SADDLEHORN RANCH FILING NO. 1

A PARCEL OF LAND LOCATED IN THE SOUTH HALF OF SECTION 3 AND THE NORTH HALF OF THE NORTH HALF OF SECTION 10,
TOWNSHIP 13 SOUTH, RANGE 64 WEST OF THE 6TH PRINCIPAL MERIDIAN
EL PASO COUNTY, STATE OF COLORADO

SADDLEHORN RANCH FILING NO. 1
JOB NO. 25142.01
APRIL 23, 2019
SHEET 1 OF 3

SADDLEHORN RANCH FILING NO. 1
JOB NO. 25142.01
APRIL 23, 2019
SHEET 2 OF 3

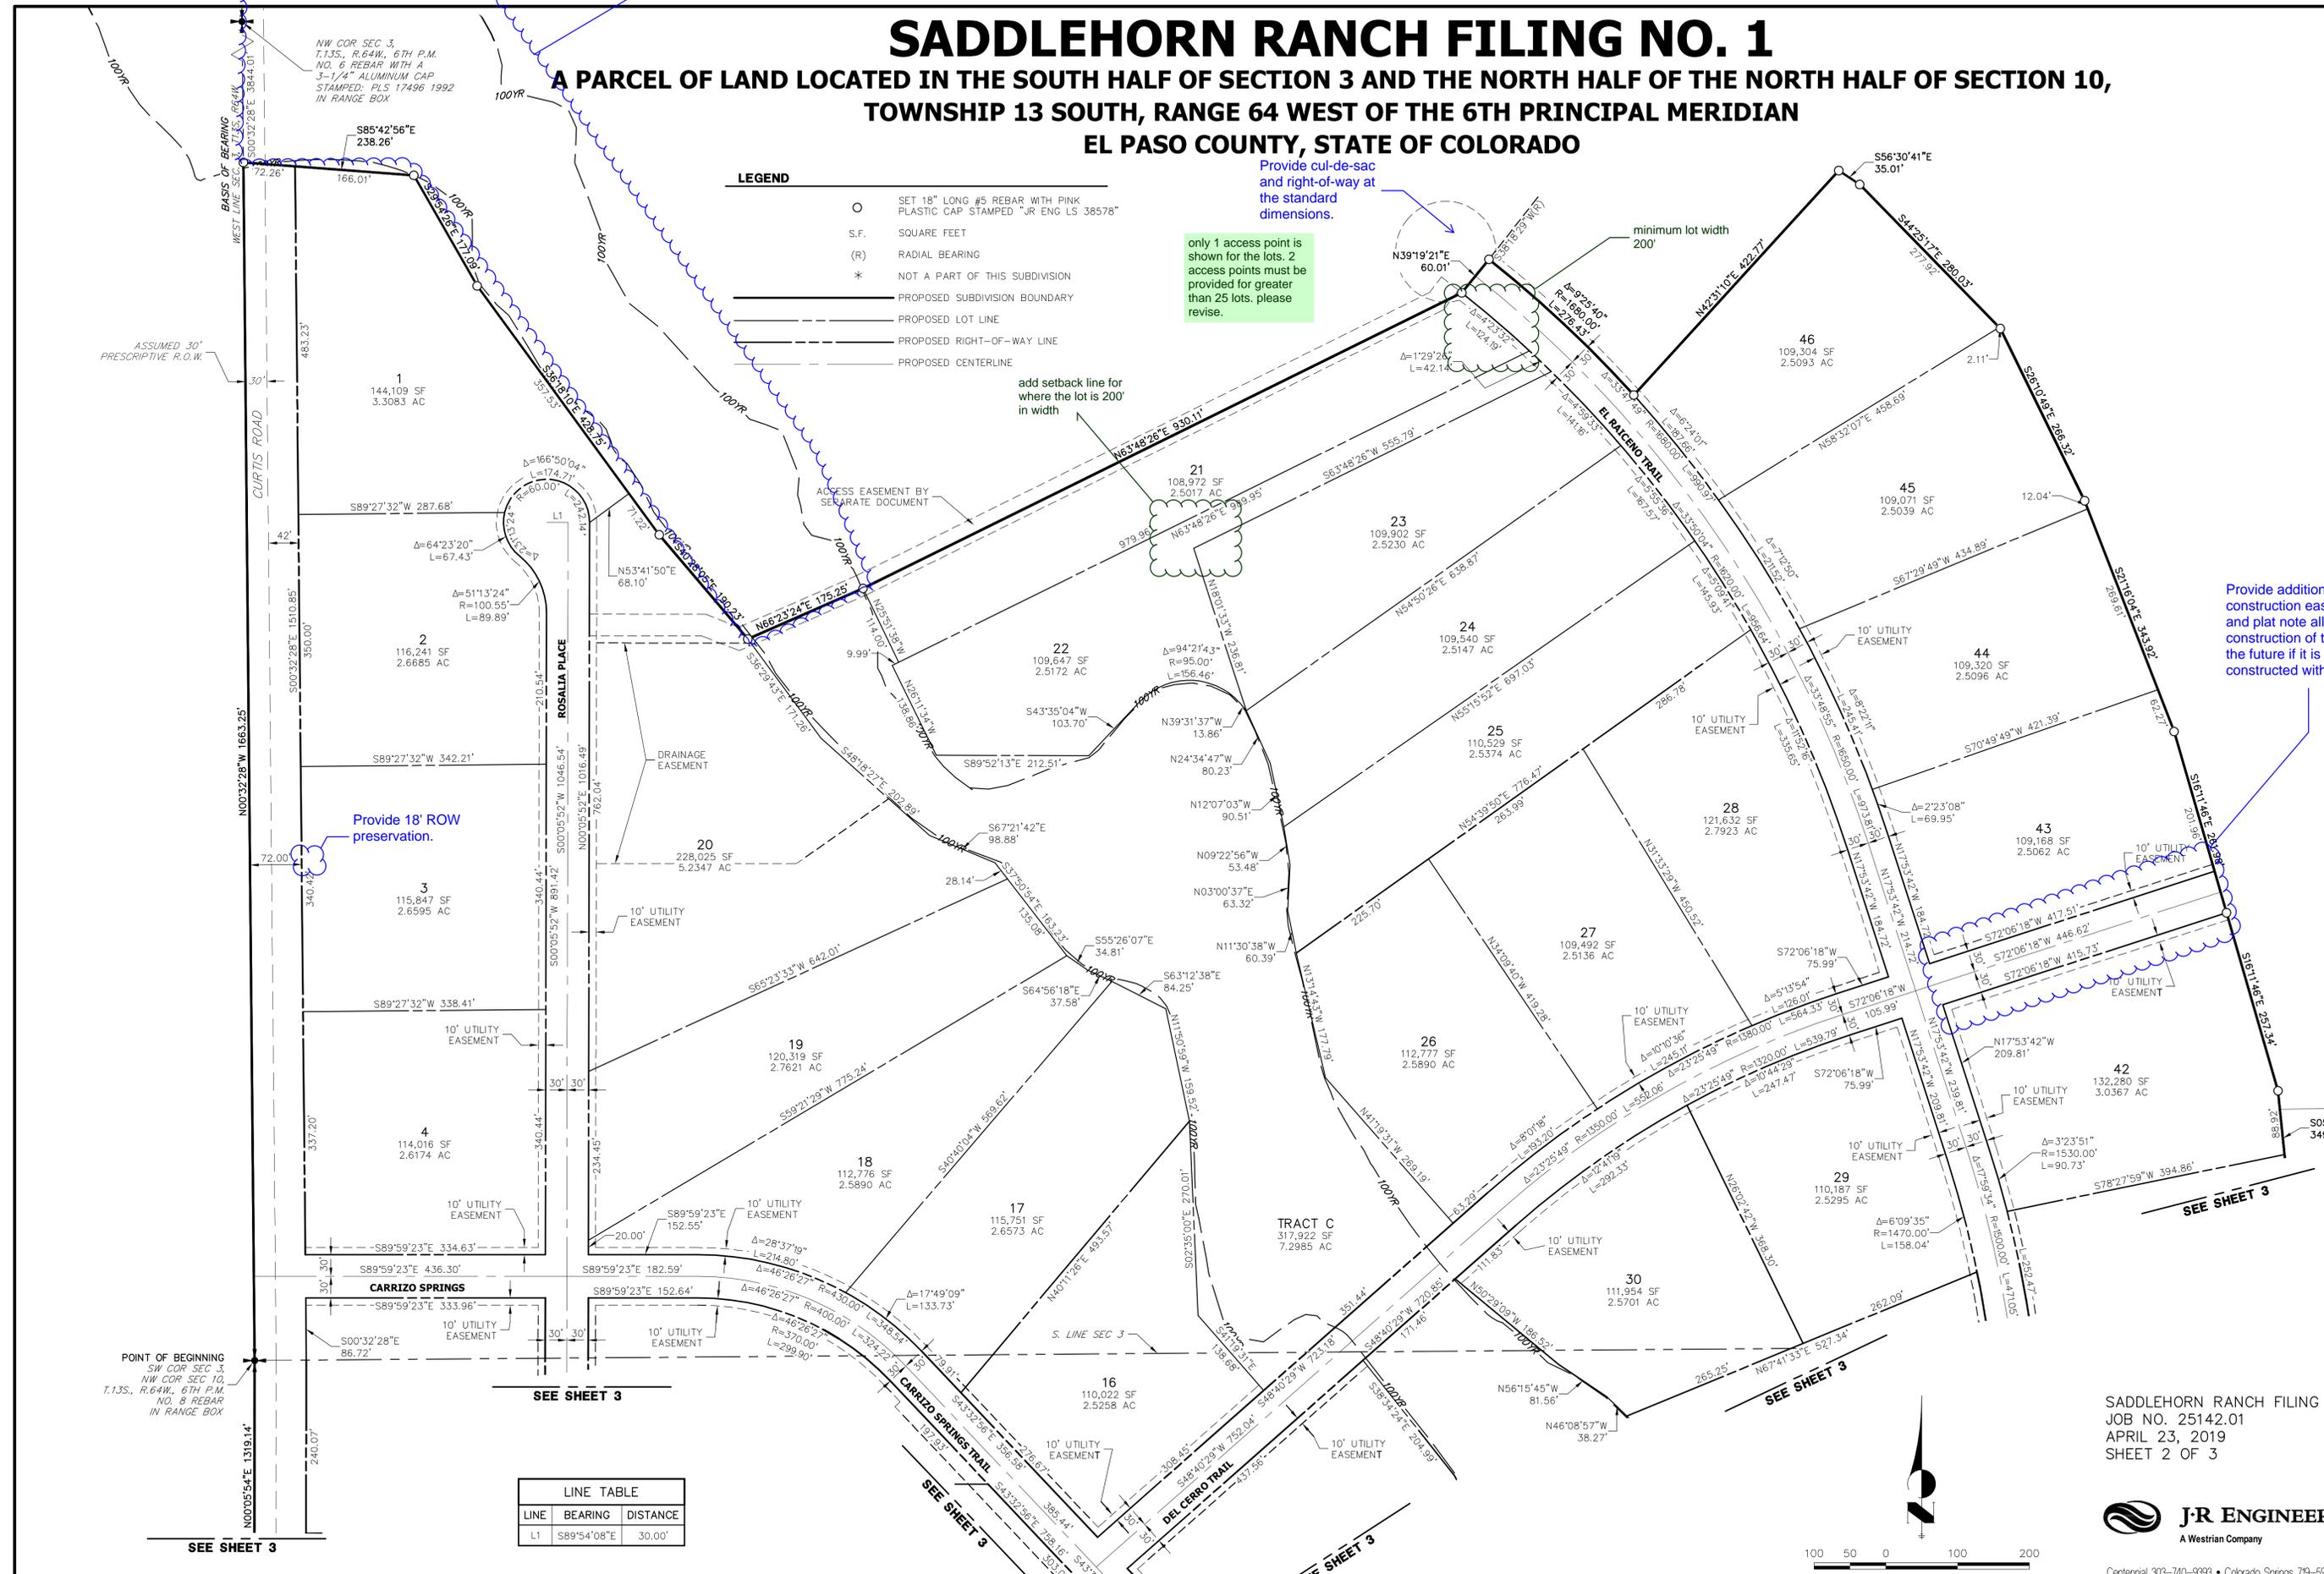
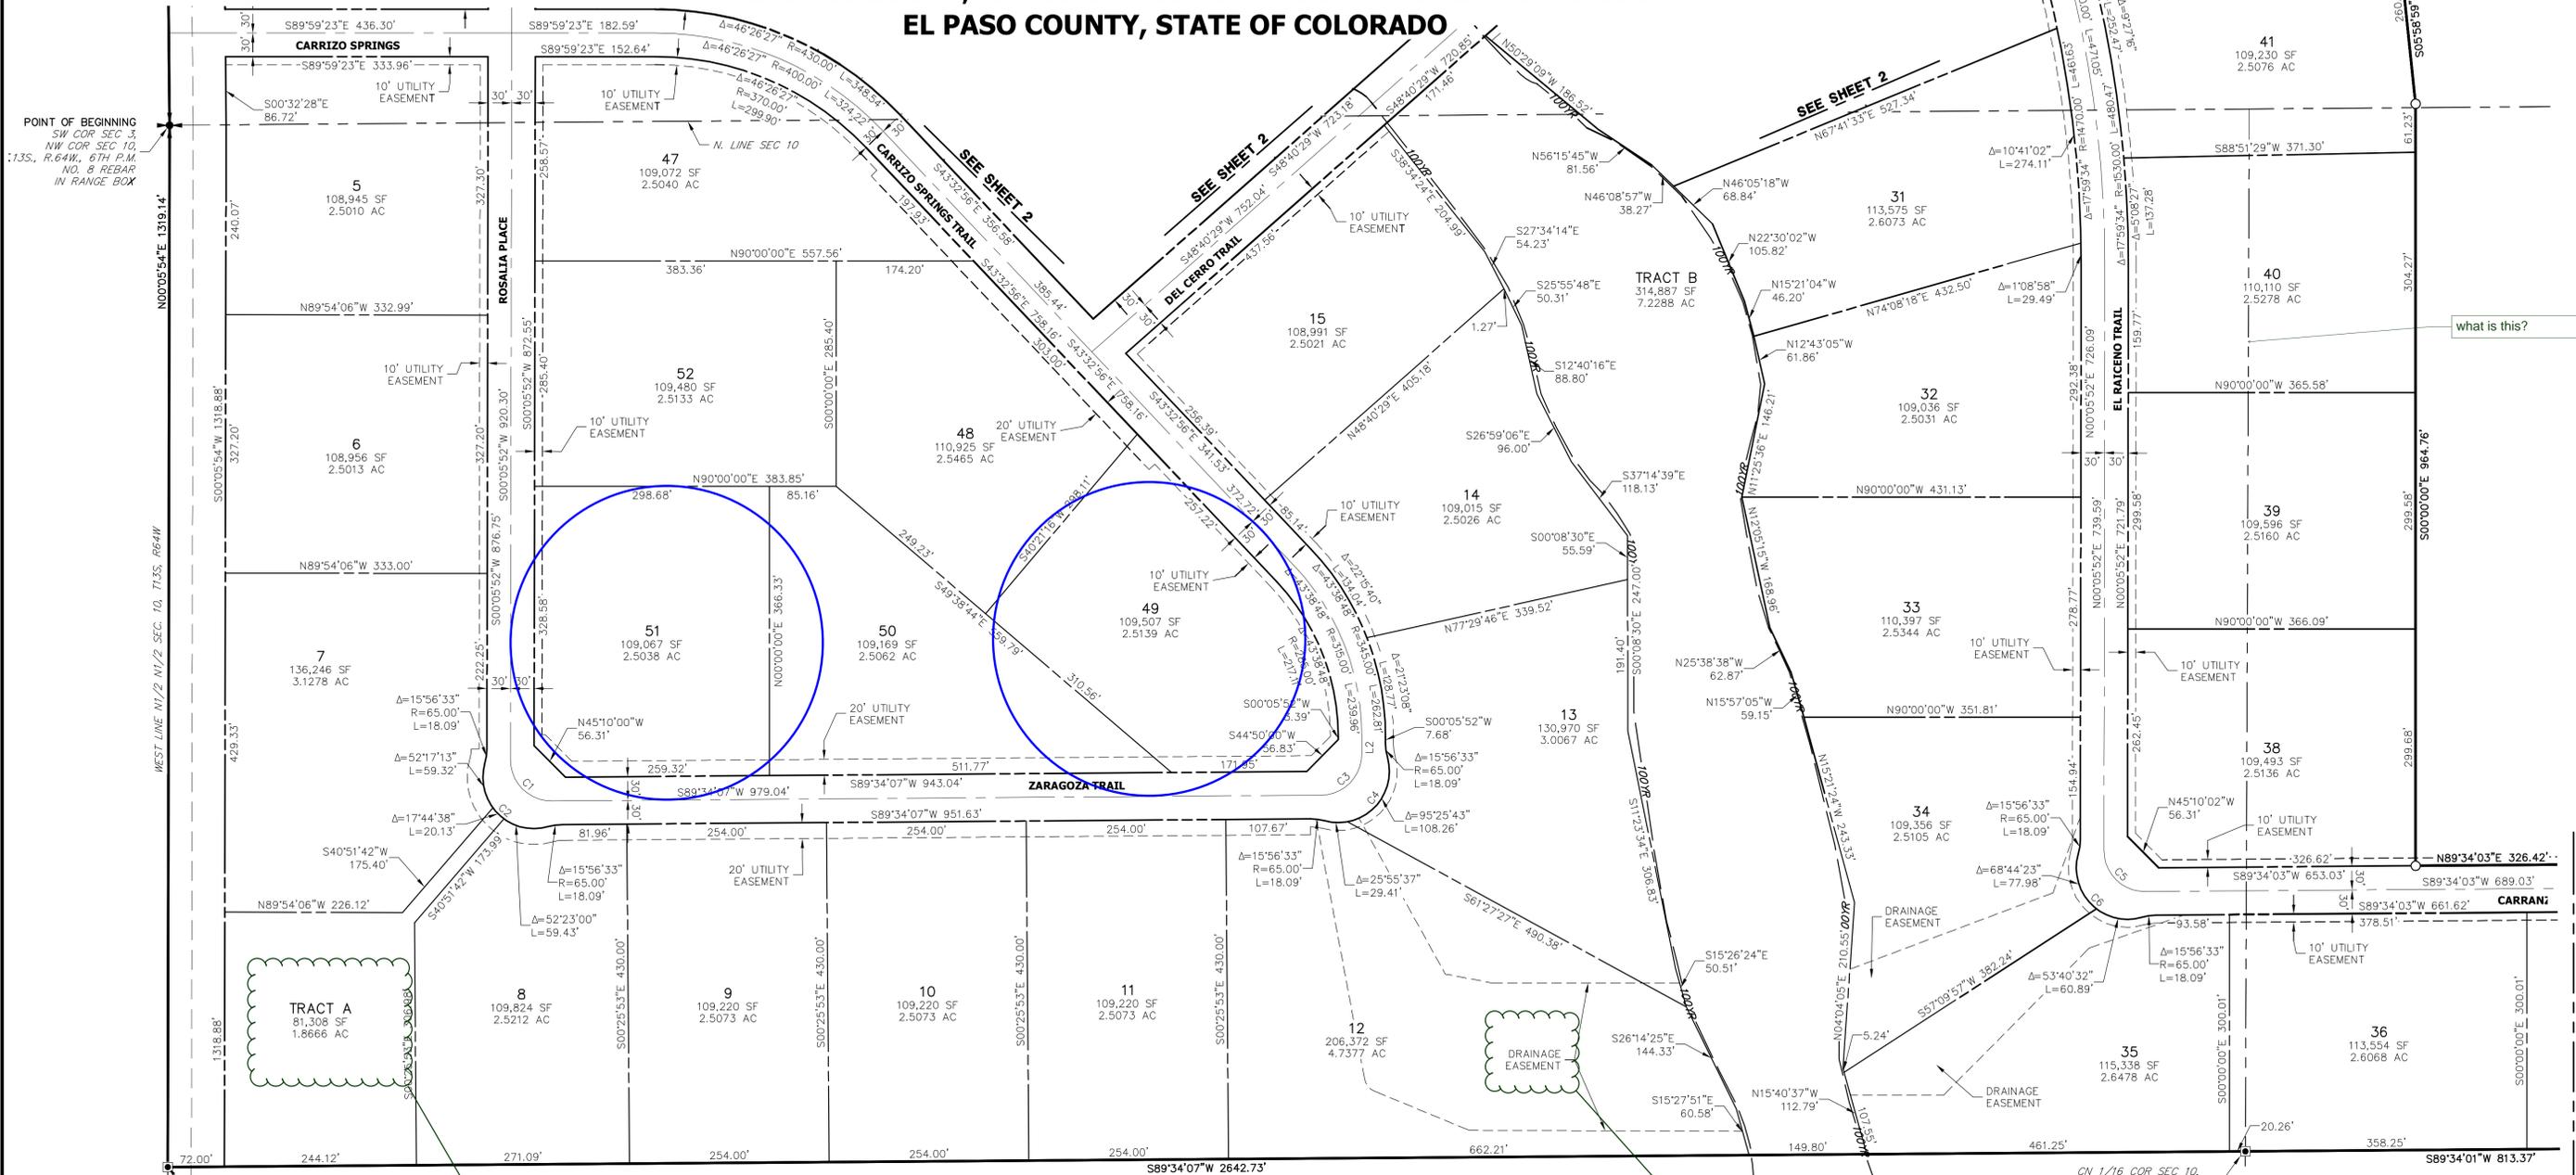
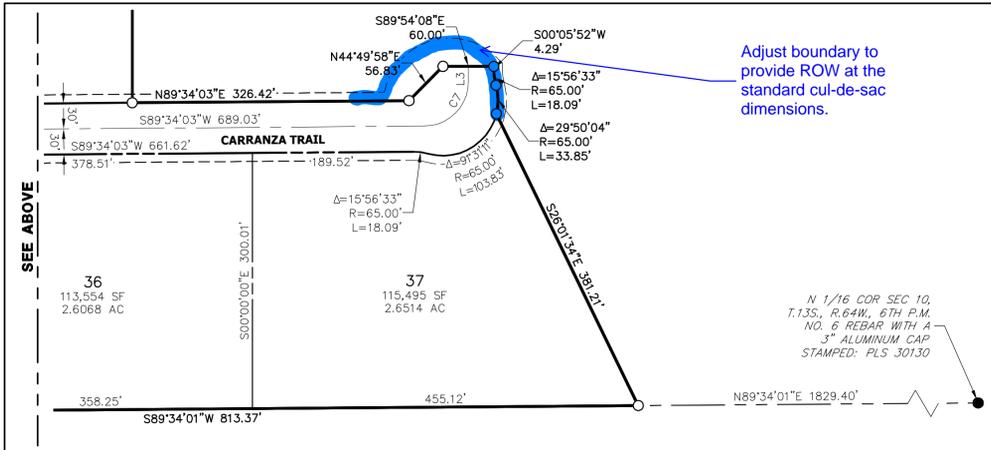
only 1 access point is
shown for the lots. 2
access points must be
provided for greater
than 25 lots. please
revise.

Provide cul-de-sac
and right-of-way at
the standard
dimensions.

add setback line for
where the lot is 200'
in width

Provide additional
construction easements
and plat note allowing
construction of the road in
the future if it is not
constructed with this filing.

Provide 18' ROW
preservation.

JR Response
Access easement by
separate document label
added.

JR Response
Not addressed, awaiting
decision on knuckle
variance

JR Response
25' Drainage, Utility and
Grading easements added
to both side of street.

JR Response
Revised as requested.
